Application SSD-8874

RE: Application for Integrated Station Development for Victoria Cross Station

Concept State Significant Development May 2018

INDICATIVE GROUND FLOOR PLAN

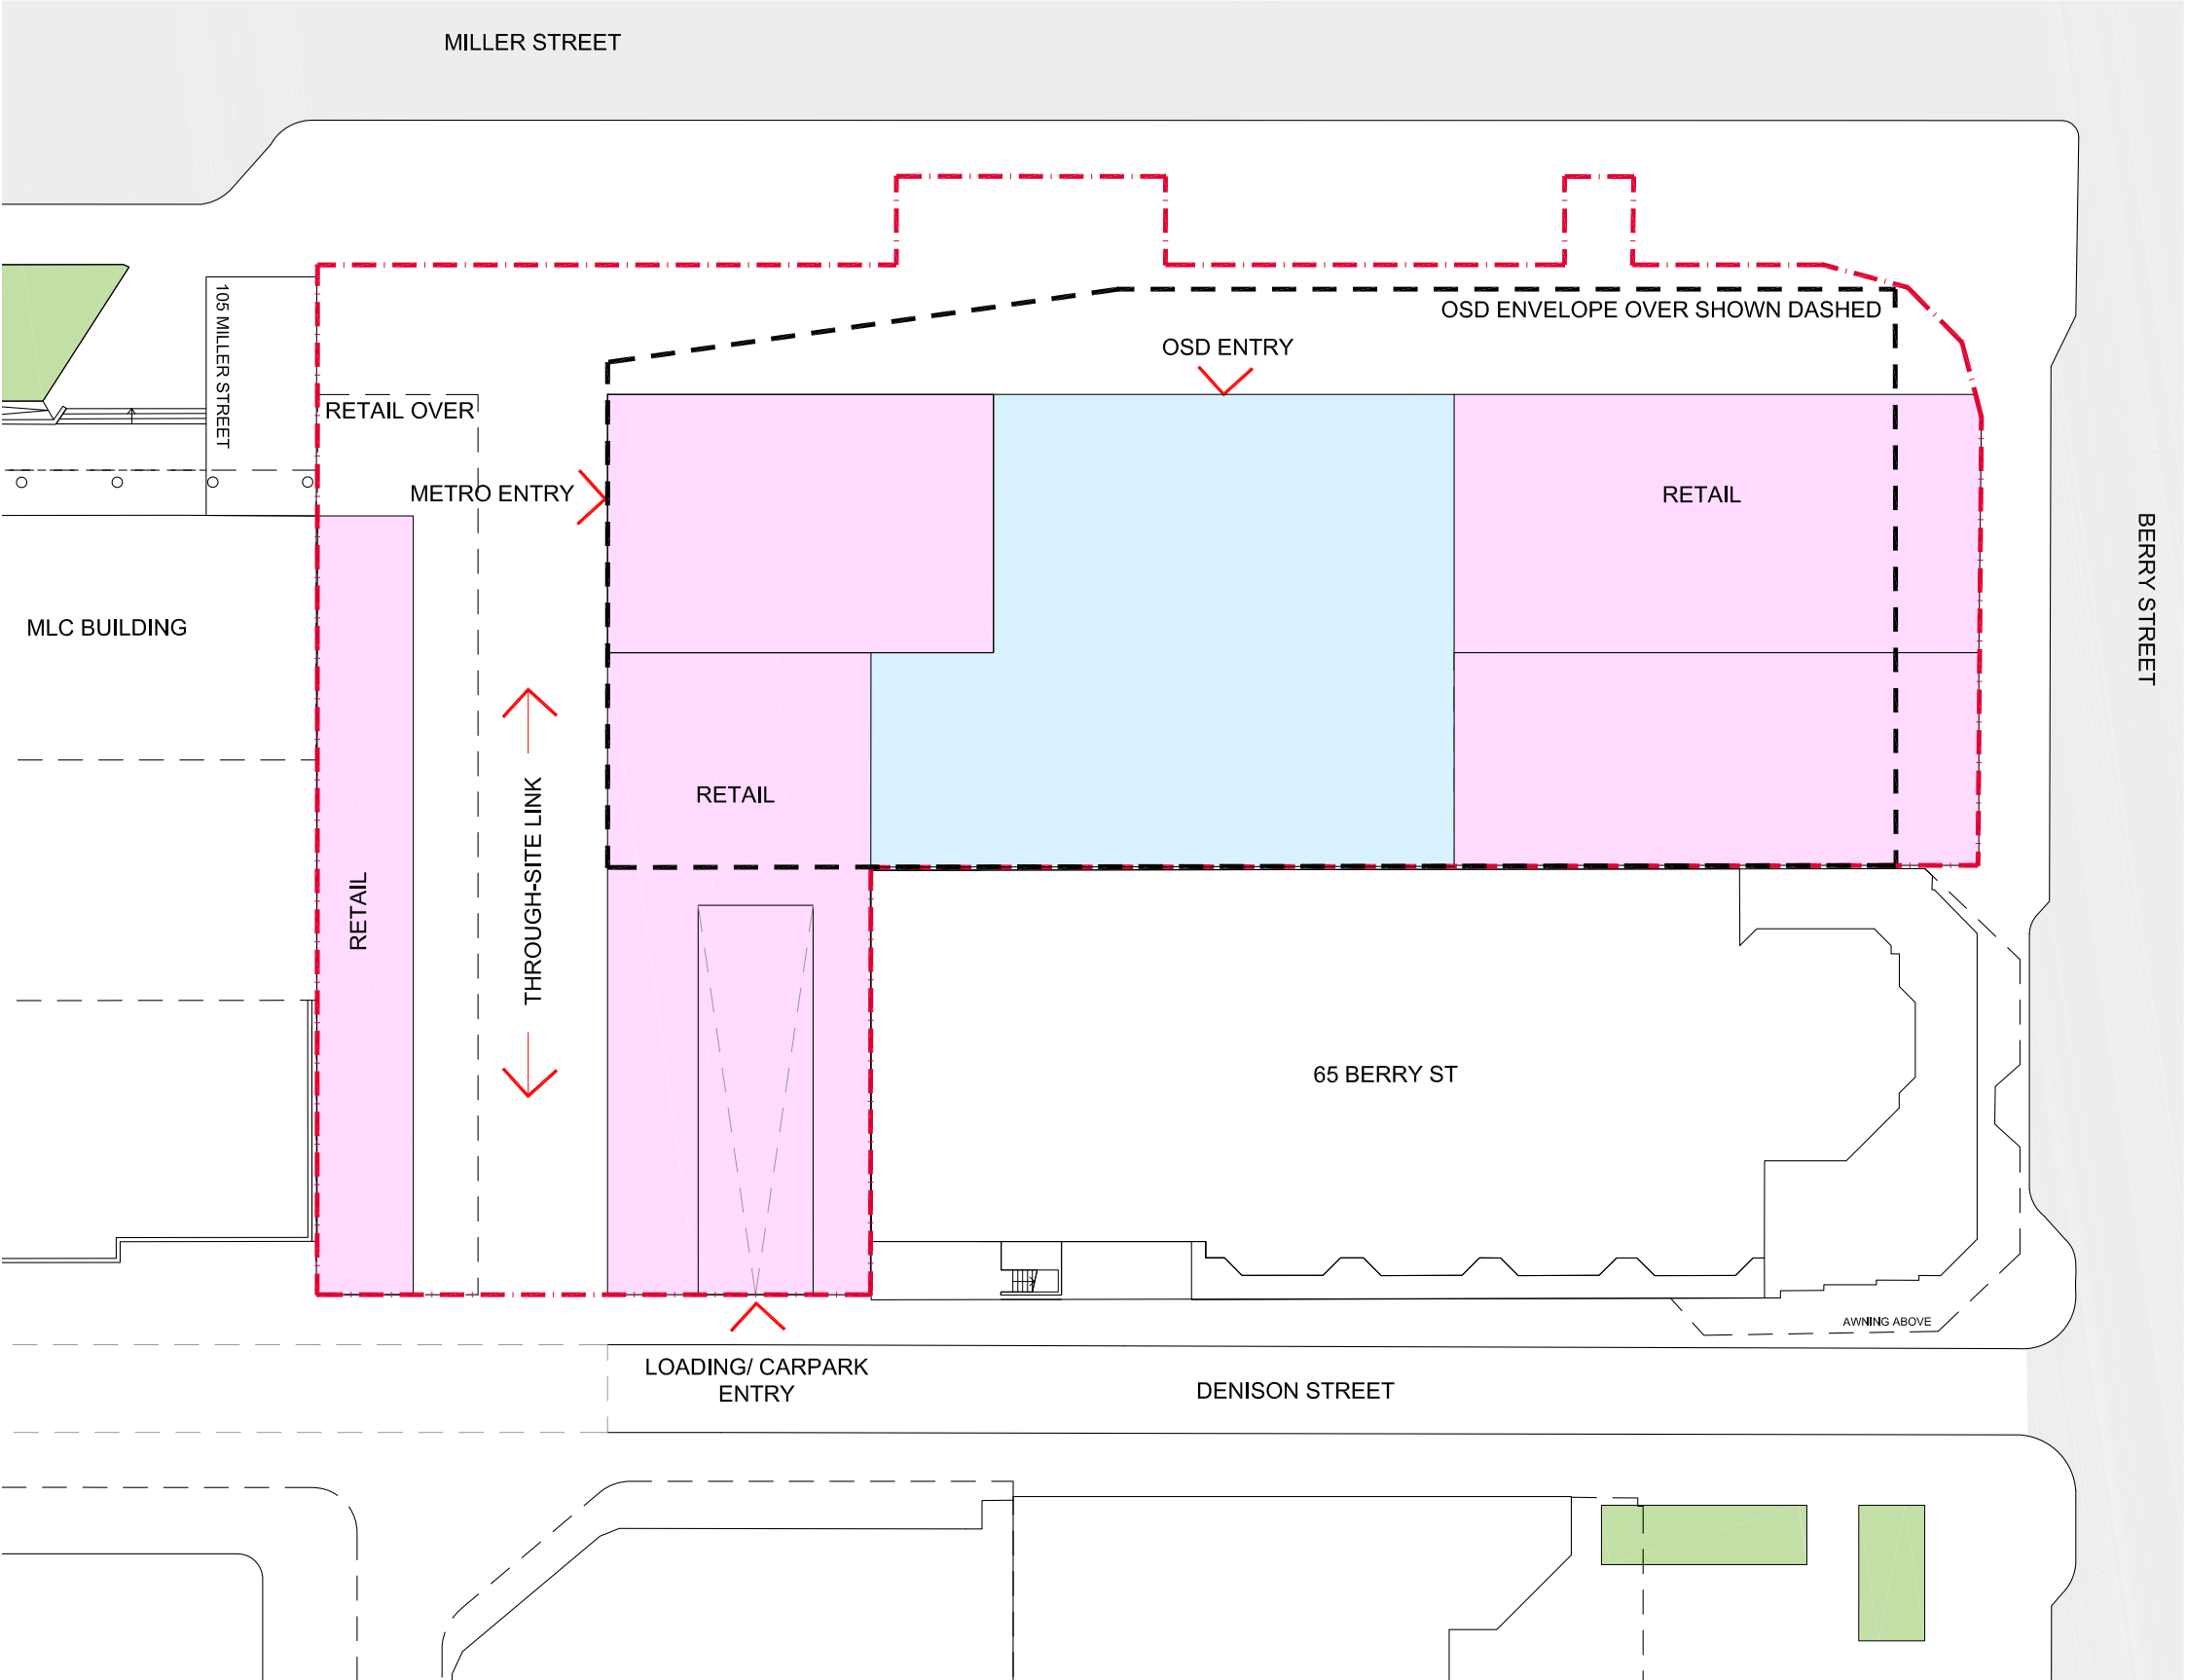
There appears to be an inadequate width of the cross block public link between Denison and Miller Streets leading to the Metro station entry. The EIS documents do not specify any dimension of the cross link but it appears on drawings within the 18m setback from the MLC building. This incorporates retail and the metro station entry which is considered to be too narrow to allow the expected 15,500 commuters using the station in the morning and evening peaks.

The artist's impressions in the Metro publications and the EIS present false images of a very generous station entry and a spacious 3 storey colonnade. The architectural plans and the physical model show no colonnade to Miller Street and only narrow pedestrian access within the 18m wide setback from the MLC building. This is deceptive and misrepresents the reality of the proposed building's inadequate public domain around the Metro station.

Setback Study — Miller Street

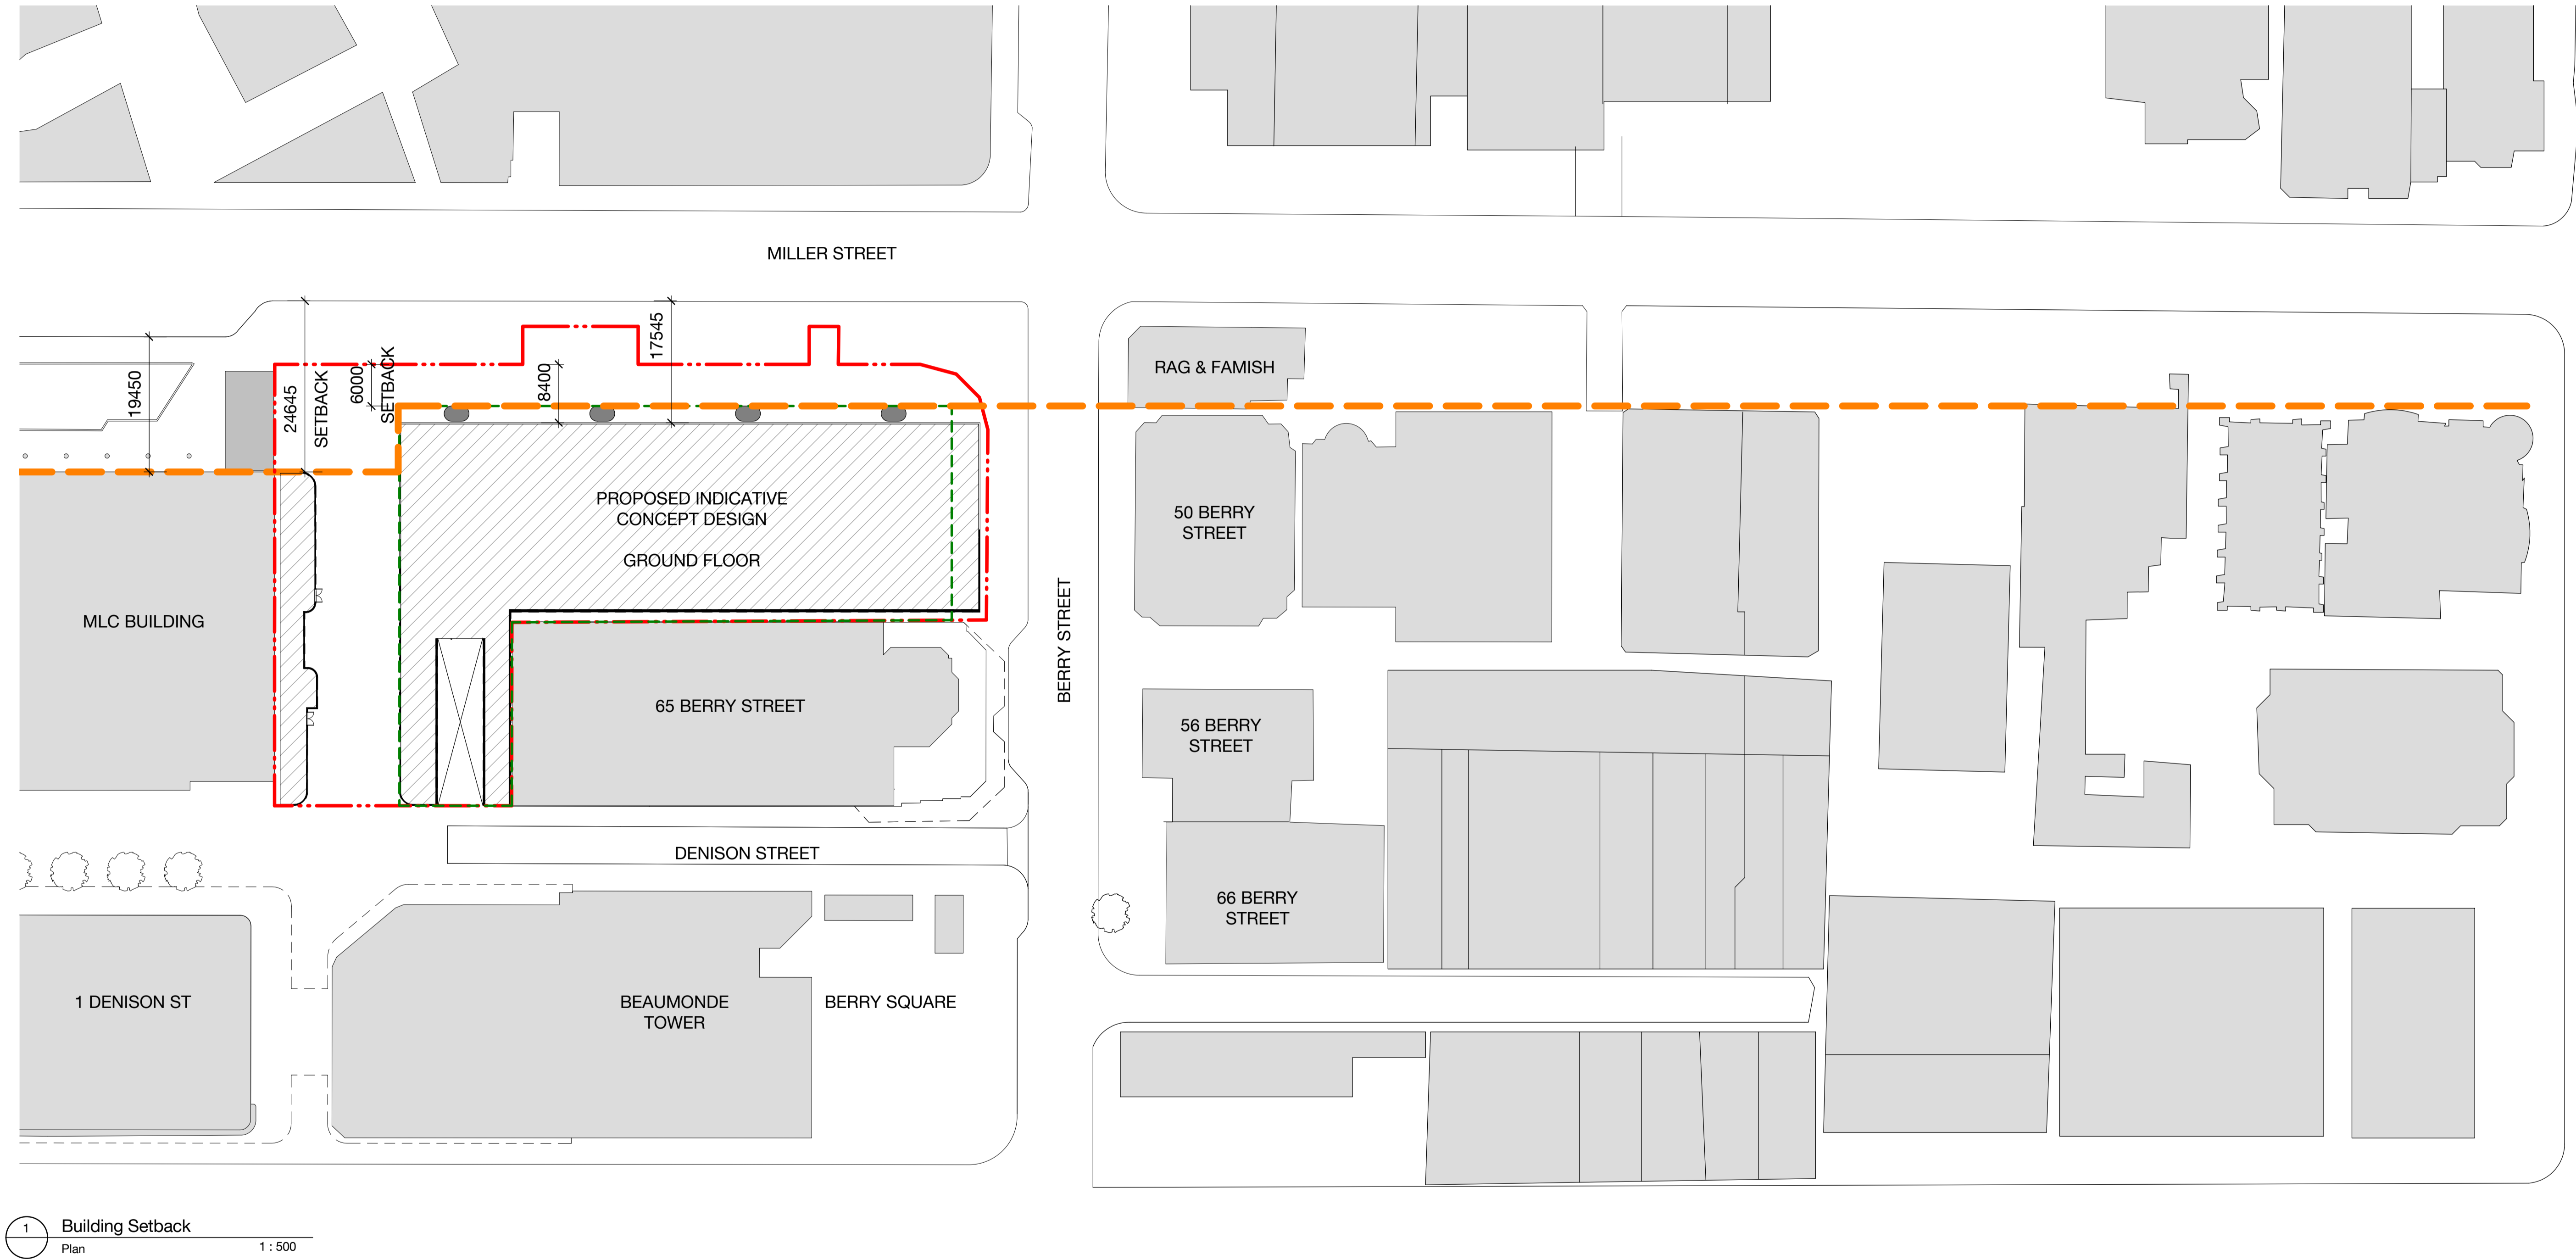
To try and achieve this excessive floorspace, the proposed building envelope encroaches significantly onto the Miller and Berry Street setbacks as defined in North Sydney Council's Planning controls. These development standards have been established to protect the winter sun access to the limited public outdoor recreation areas in the centre of North Sydney. It is astounding that this proposal neither respects or complies with these.
